Charlotte Department of Transportation

Memorandum

Subject: Rezoning Petition 08-077: Located between North Wendover Road and Billingsley Road at Cascade Circle

SCHEMATIC SITE PLAN

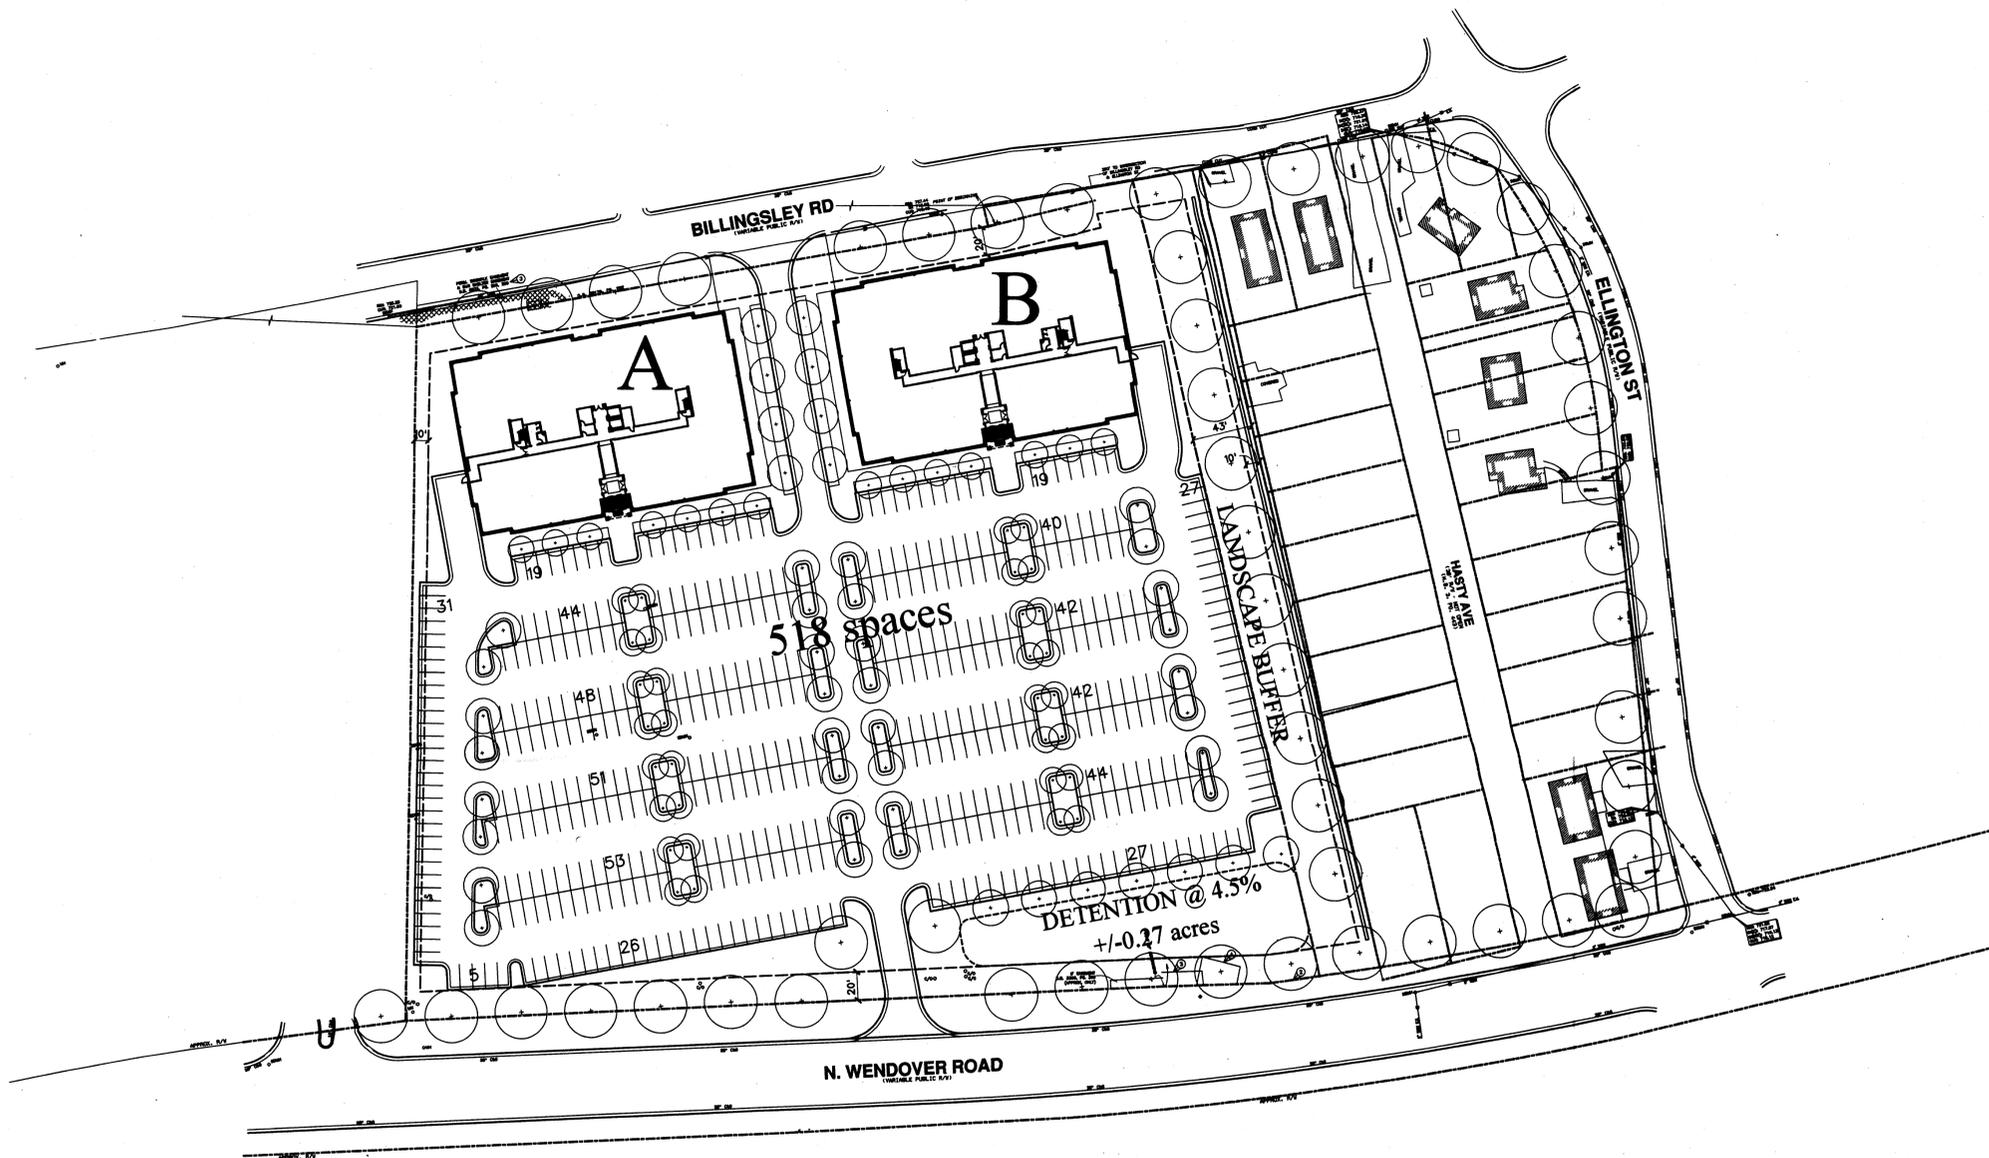
1. CDOT will support the abandonment of Cascade Circle as shown on the site plan provided that a new public street is constructed by the petitioner between Billingsley and North Wendover Roads. This new public street can be in the same location as the proposed internal driveway but needs to be redesigned as a Local Commercial Street with fewer driveway access points and planting strips/sidewalks on both sides of the street. The Local Commercial Street (USDG) has a minimum back-of-curb/back-of-curb width of 25 feet for a mixed vehicle zone (if no dedicated on-street parking), 8-foot planting strips, and 5-foot sidewalks.

2. 8-foot planting strips and 6-foot sidewalks are required along the site's frontages on both Billingsley and North Wendover Roads. For North Wendover Road these improvements need to be measured from the future back-of-curb.
3. The required 6-foot sidewalk needs to connect with existing pedestrian facilities adjacent to the property. The site plan base survey needs to be updated to show existing sidewalks in order to fully-evaluate pedestrian connectivity.
4. North Wendover Road is a state maintained road. The NCDOT may require a left and/or right-turn lane at the connection to North Wendover Road whether it is a new public street or a new driveway connection. The petitioner may contact Louis Mitchell, NCDOT District Engineer at 704.596.6900 to determine whether turns lanes will be required.

1. The designation and redesign of the current internal driveway linking Billingsley and North Wendover Roads will also create new front yard setbacks per zoning impacting the current locations of Buildings A and B. These buildings could possibly shift away from the new street or turn 90-degrees to accommodate resulting setbacks.

Adequate sight triangles must be reserved at the existing/proposed street entrance(s). Two 35-foot x 35-foot and two 10-foot x 70-foot sight triangles are required for the entrance(s) to meet requirements. All proposed trees, berms, walls, fences, and/or identification signs must not interfere with sight distance at the entrance(s). Such items should be identified on the site plan.

- All City of Charlotte Land Development Standards (latest revision) will apply.
- Dimension width of the existing and proposed driveways.
- New/reconstructed driveways must be drop curb ramp Type II-Modified driveways.
- Indicate the locations and widths of all adjacent and opposing driveways.
- Indicate typical parking module dimensions.
- Directional wheelchair ramps (two per corner) should be provided at all intersections of public and private streets.
